SUBMISSIONS REPORT

Modification of Project Application No. 06_0205 (Mod 3)

Vincentia District Centre

for Fabcot Pty Ltd

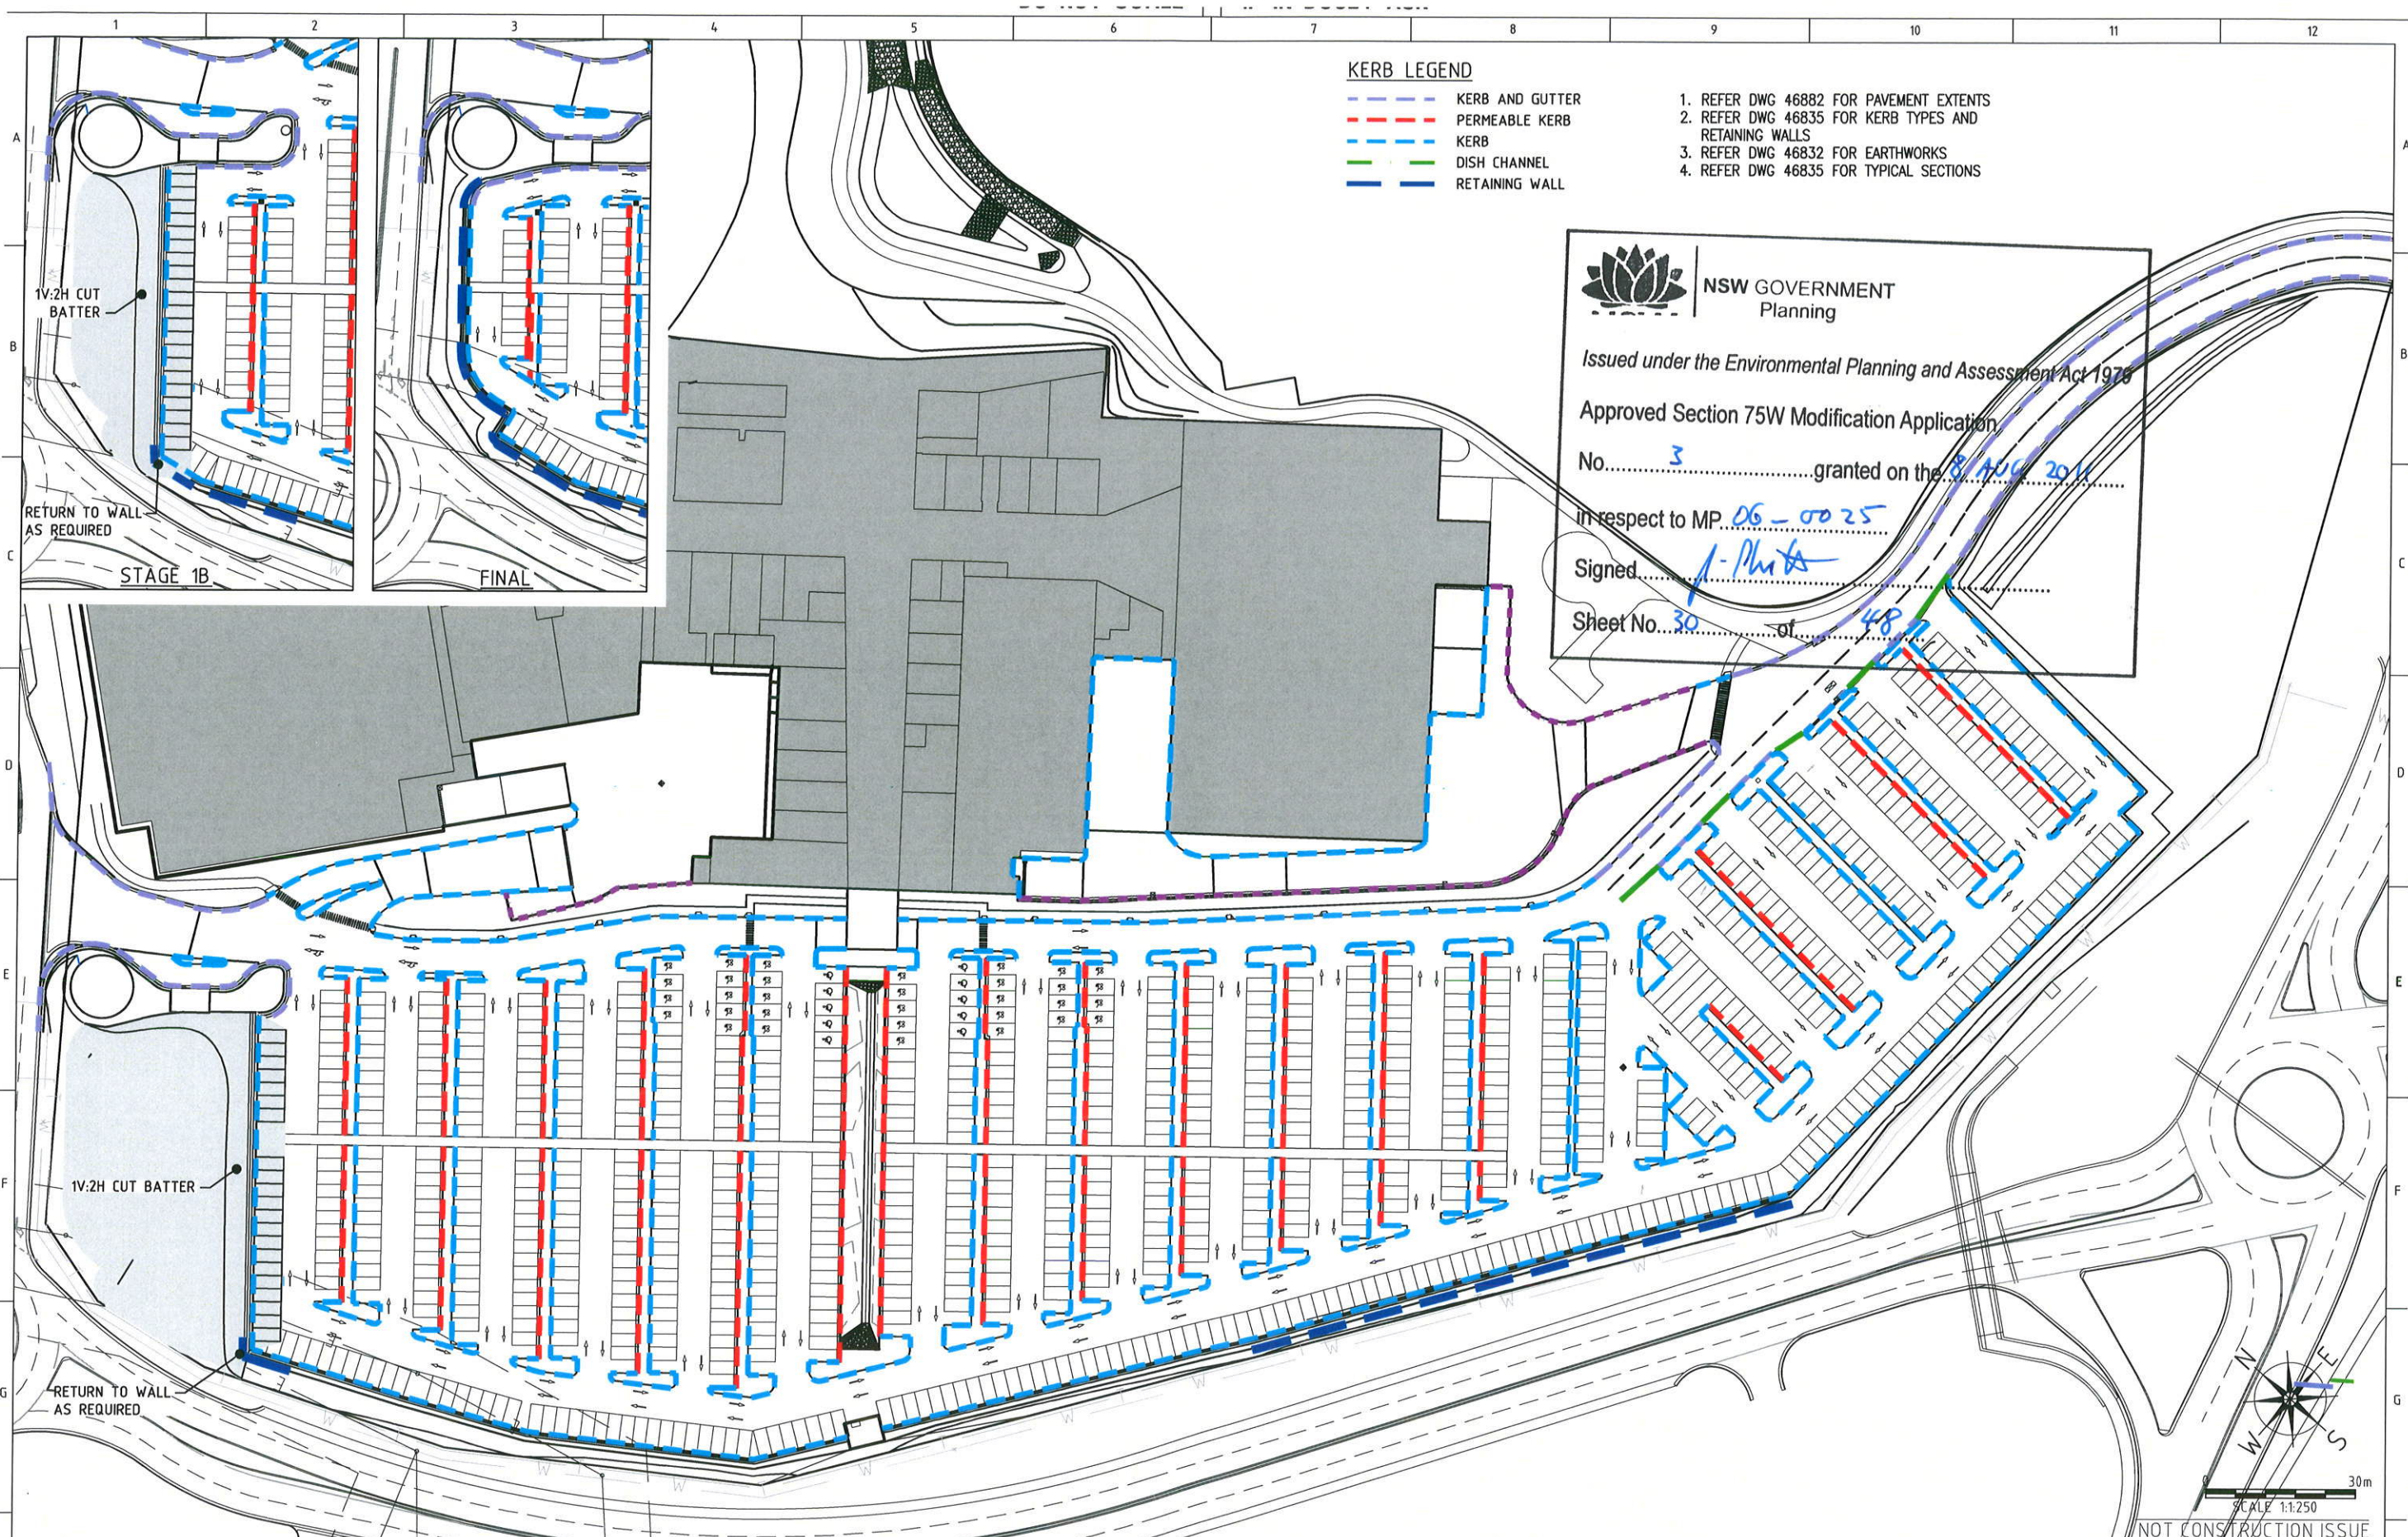
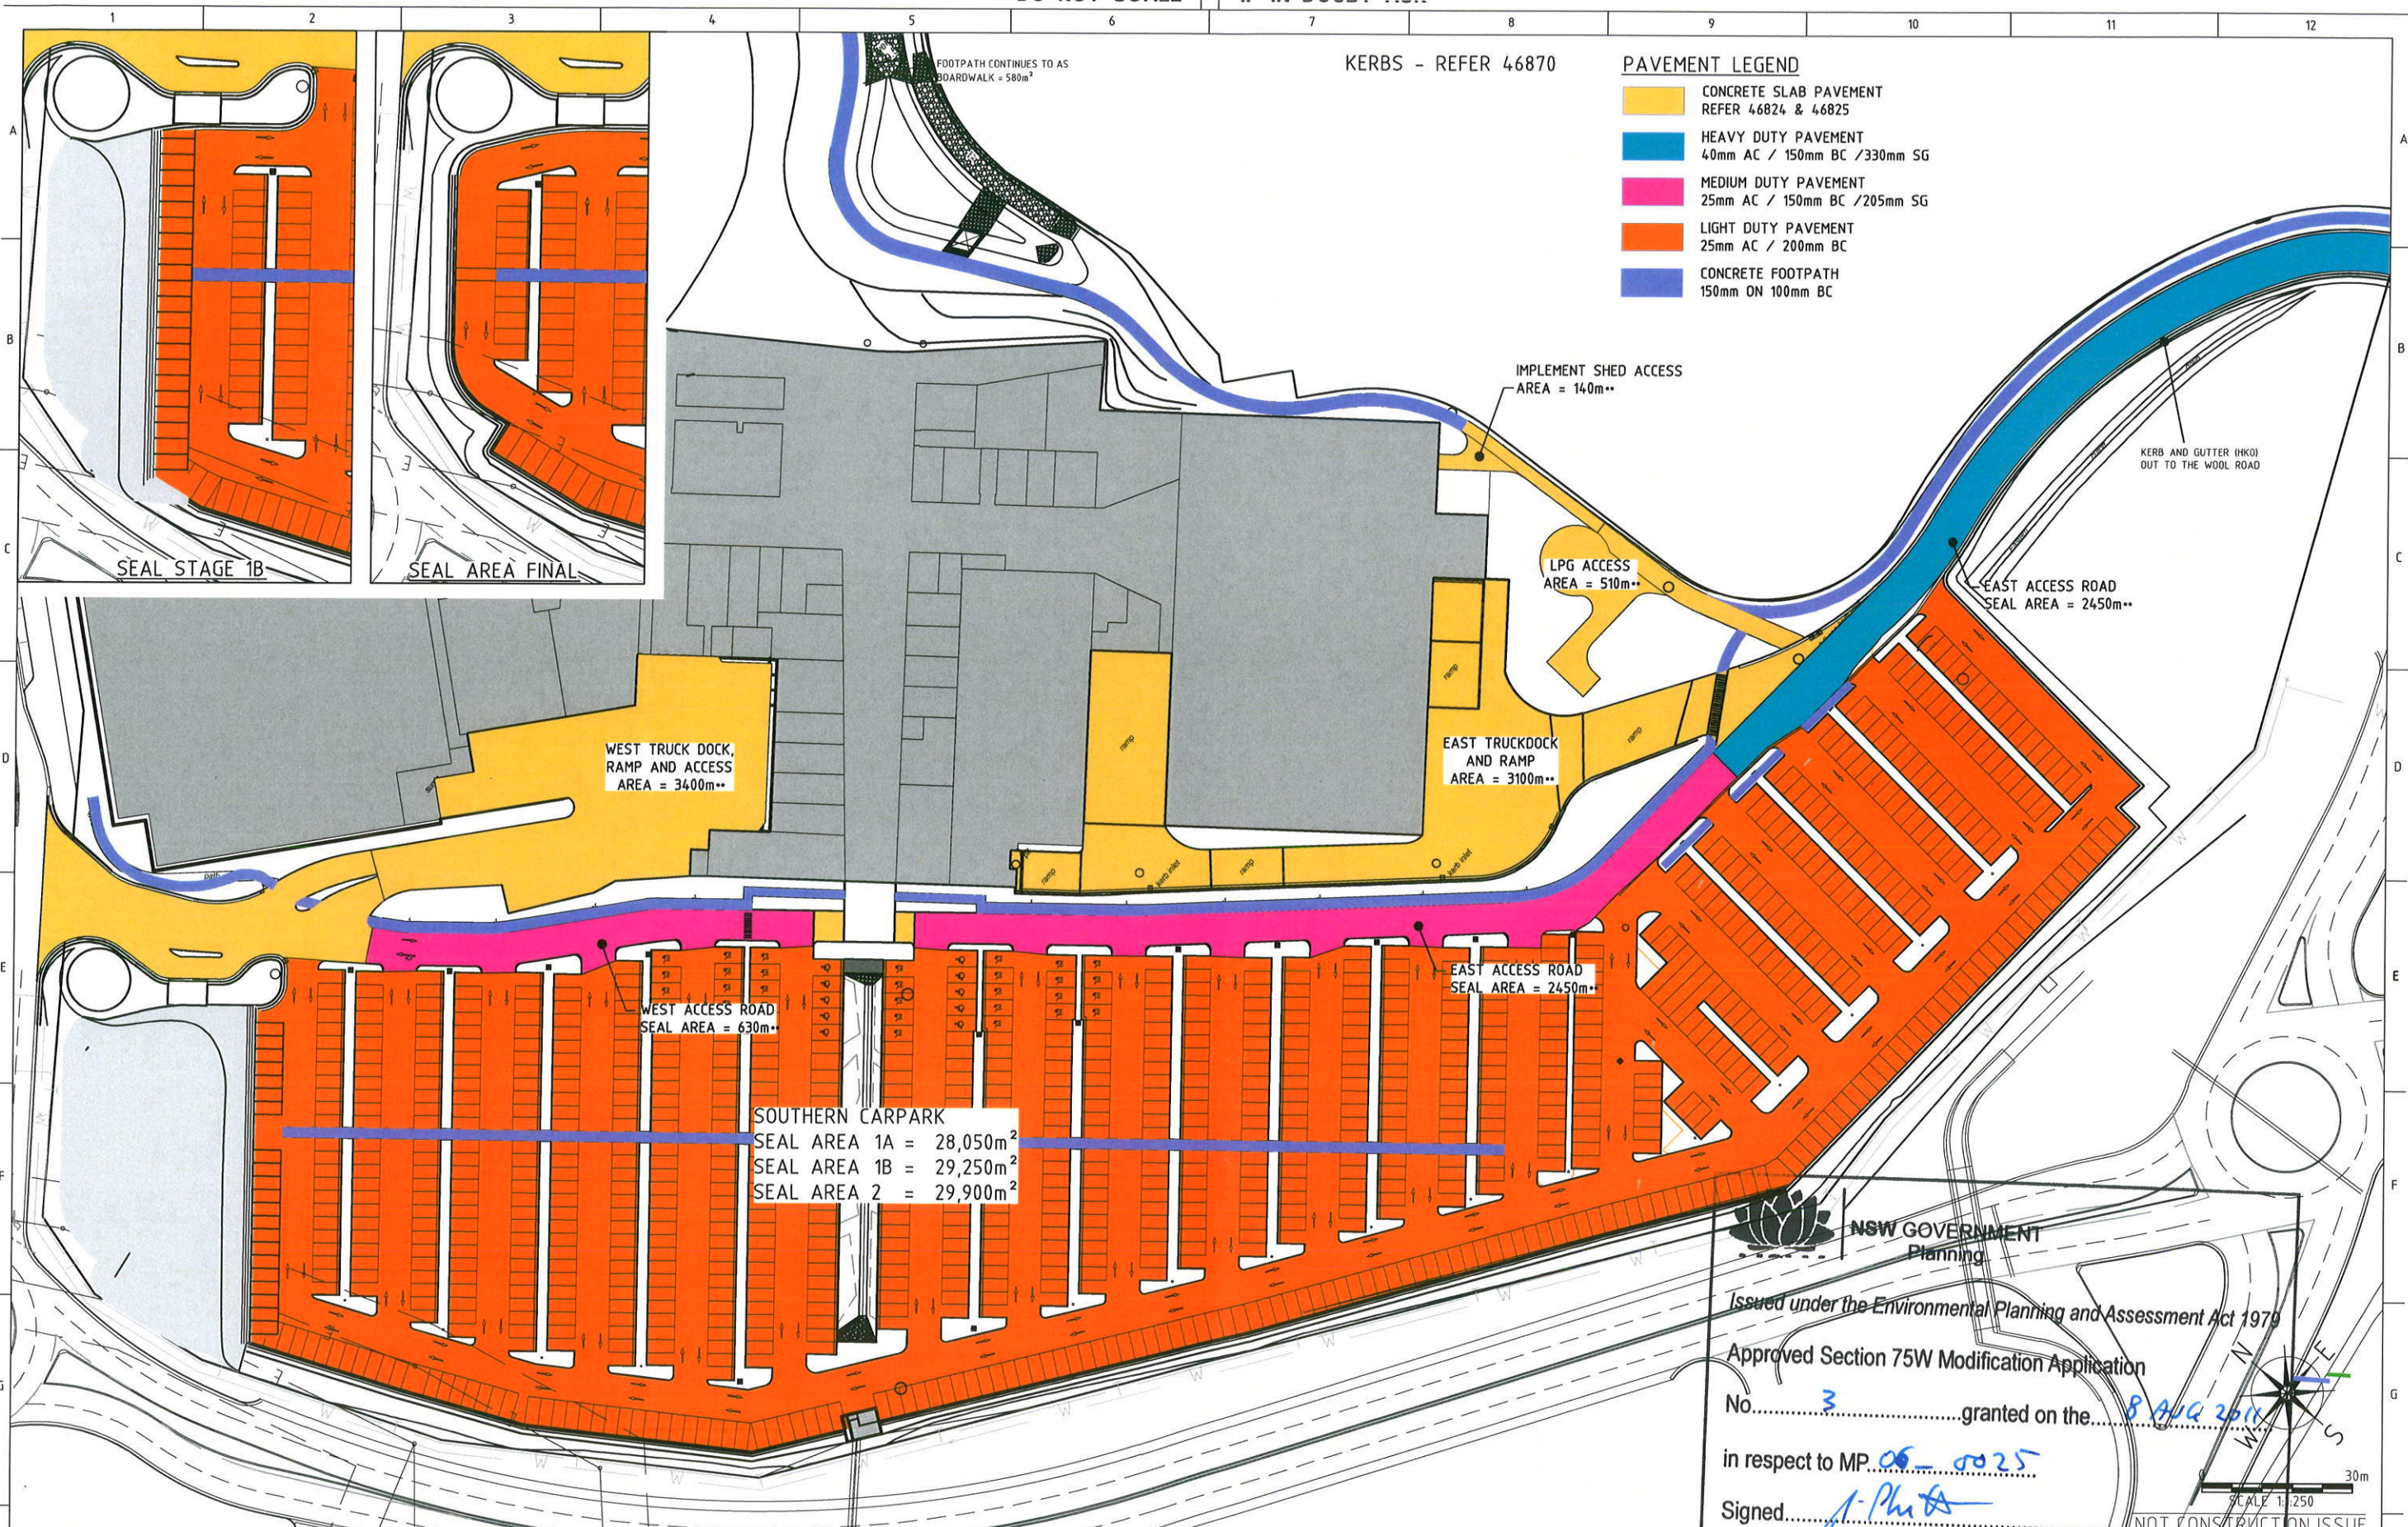
4.1	<i>Anomaly on Cardno plan reference to long vehicle parking.</i>	<p>Civil drawings have been amended accordingly, refer to Appendix B.</p>
5.0	<i>Council requests that the commitments in SoC 11, 28, 29, 30, 31, 45 and 46 not be accepted as proposed and that the full description of the commitment be stated, not just a reference to a clause number in the Mod 2 approval. The reason is that the modified SoC should stand alone for clarity of future</i>	<p>No changes are proposed to these commitments in Mod 3. The proponent does not agree and Mod 3 does not seek to amend these elements which formed part of Mod 2 approval.</p>

MOONA CREEK ROAD, ENTRY PLAZA TO TOWN CENTRE & ARBOURWALK

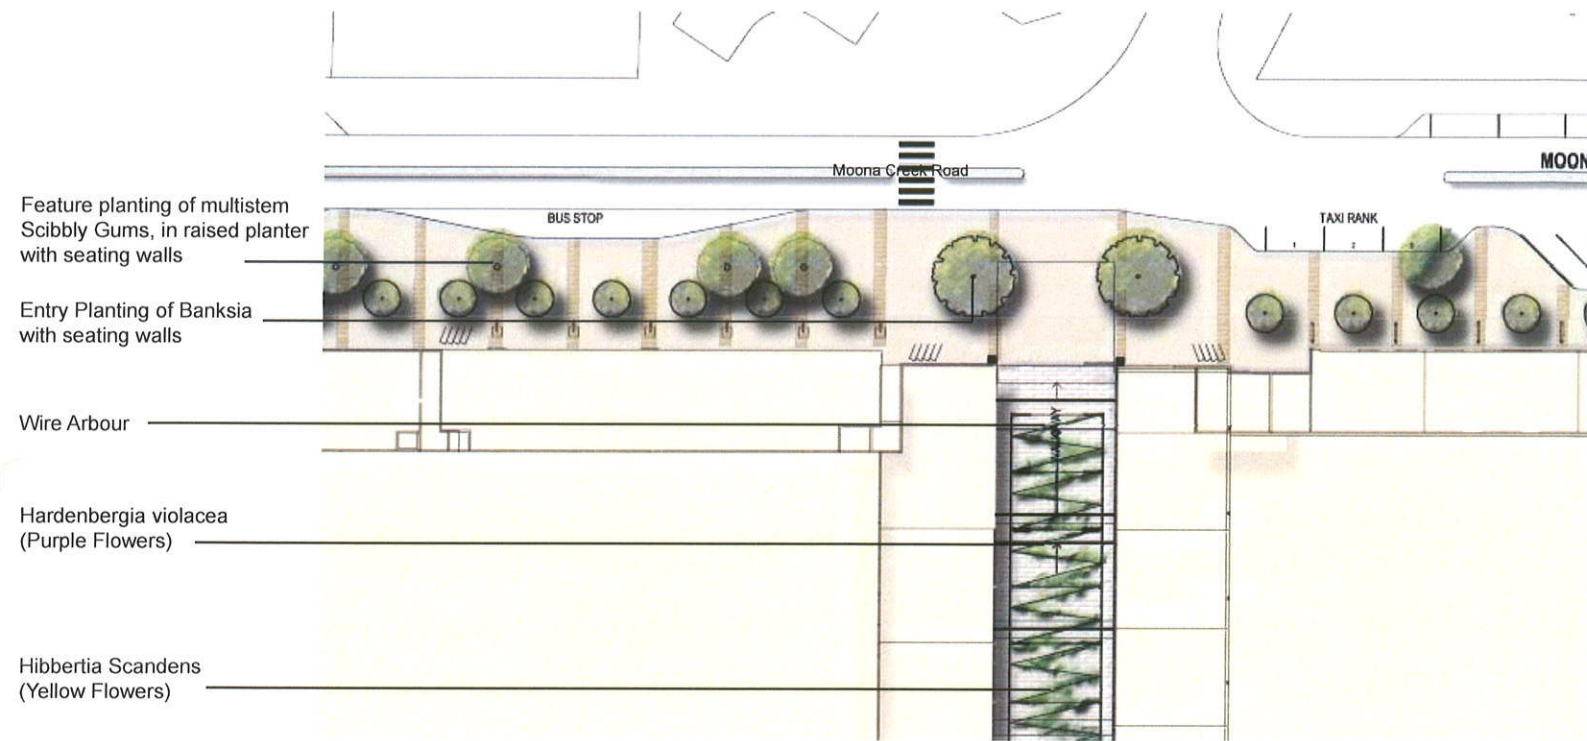
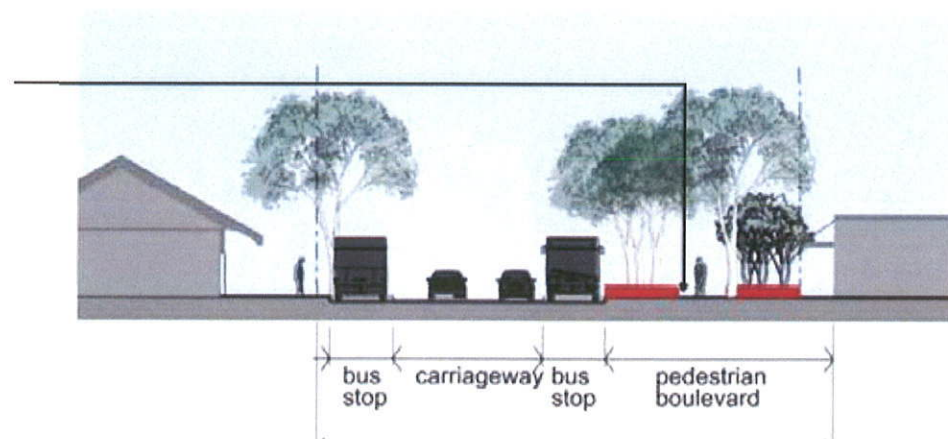
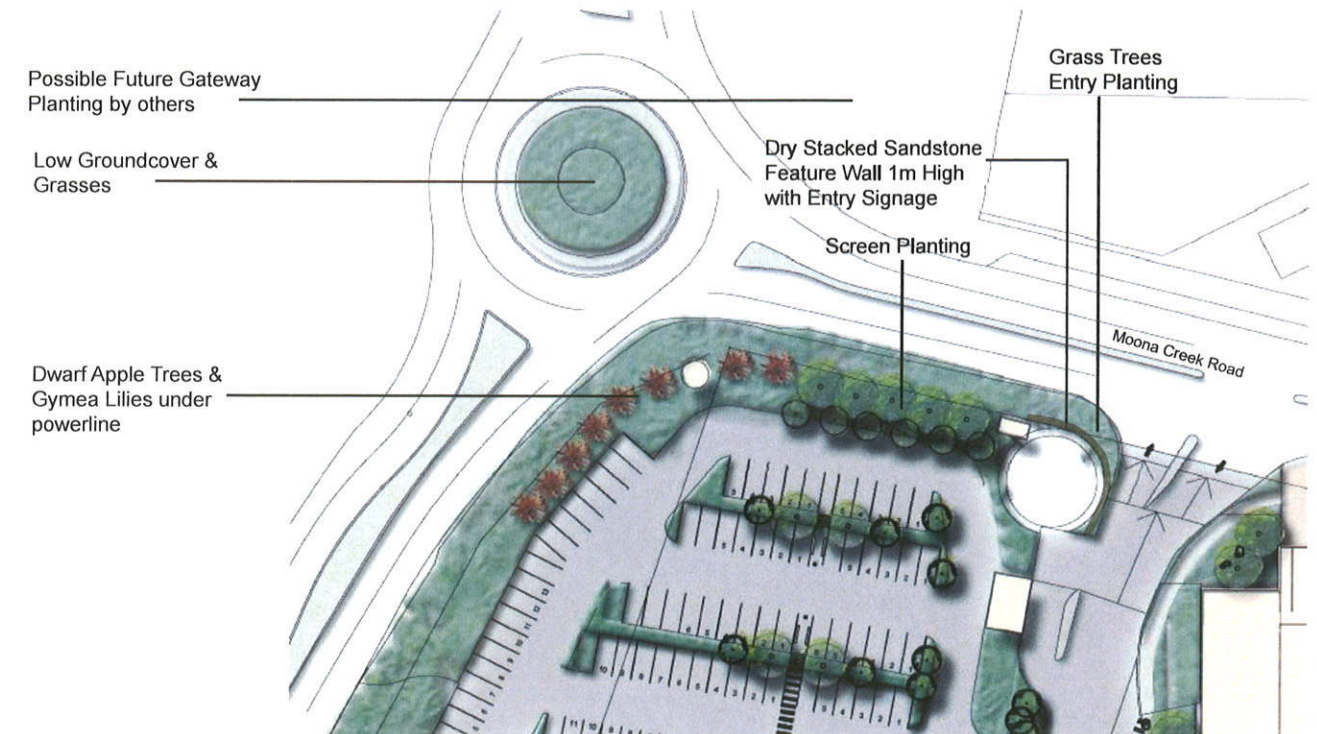
3.3	<i>•Pedestrian refuges should be located in the median strips and a single marked zebra crossing alone is unacceptable on Moona Creek Road given the volume of vehicles this road will eventually carry.</i>	Drawing information has been amended – refer to Appendices A, B and C.

- Same as for LA-03
- Extend south east car park for additional spaces per RD revised staging plan
- LA-05 Issue E -Dated 06.07.2011
 - Revised Moona Creek Road parking layout as above
 - Revised south east corner car parks per final stage 2 plan (RD- DA-1203)
- LA-07 Issue E -Dated 05.07.2011
 - Detail B- Added notes ref feature stone wall and screen planting to sprinkler tank
